From: Kate Giddings <kate.giddings@arun.gov.uk>
Sent: 17 December 2019 13:59
To: Anita Gardner <Anita.Gardner@arun.gov.uk>
Cc: Planning.Responses <Planning.Responses@arun.gov.uk>
Subject: LU/354/19/DOC - land south of Cornfield Close, Littlehampton

In relation to the above application, the discharge of conditions 9 (contaminated land) and 15 (electric vehicle charging points) cannot be considered by this Department at this stage because:

REV	DATE	NOTE
DEVELOPMENT		
CORNFIELD CLOSE LITTLEHAMPTON		
DRAWING TITLE		
PARKING PLAN

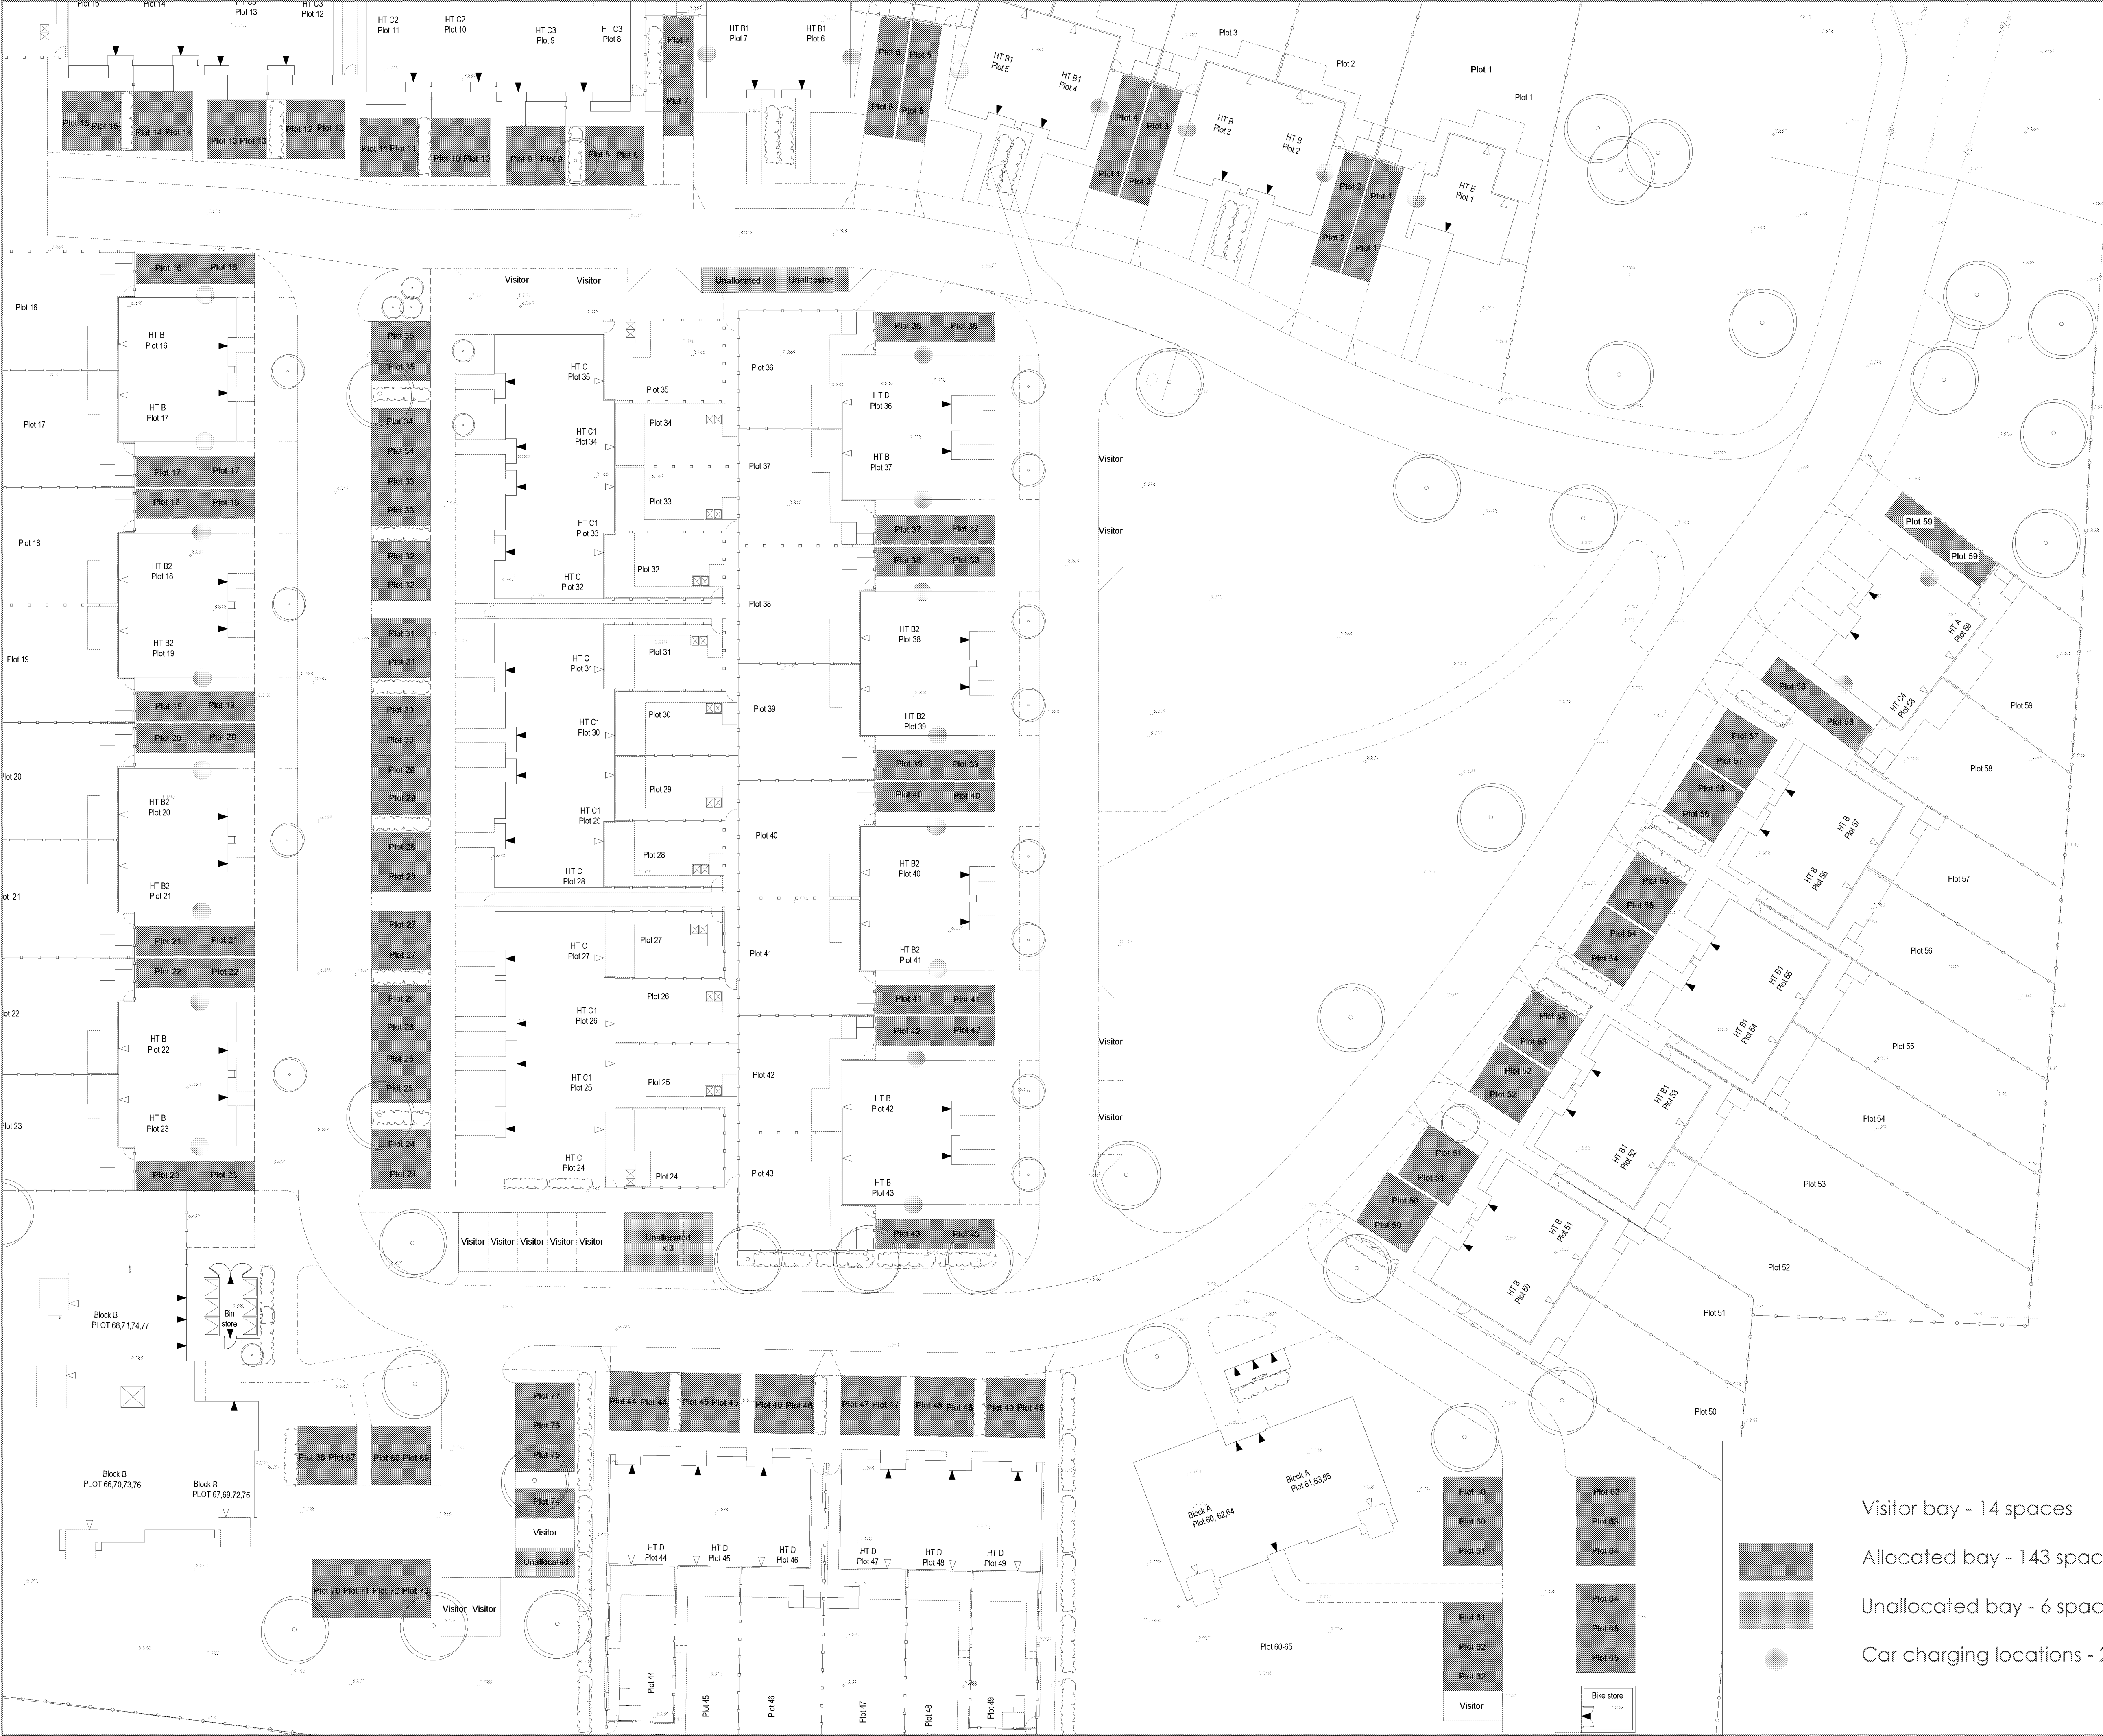
- the number of charging points (25) in relation to the number of dwellings (77) does not appear adequate. May the applicant also please provide a scheme (to accompany the submitted plan) of electric vehicle charge points (to include information on how the plan will be implemented, details of accessibility provision(s) and the ratio between occupants/dwellings and charge points).
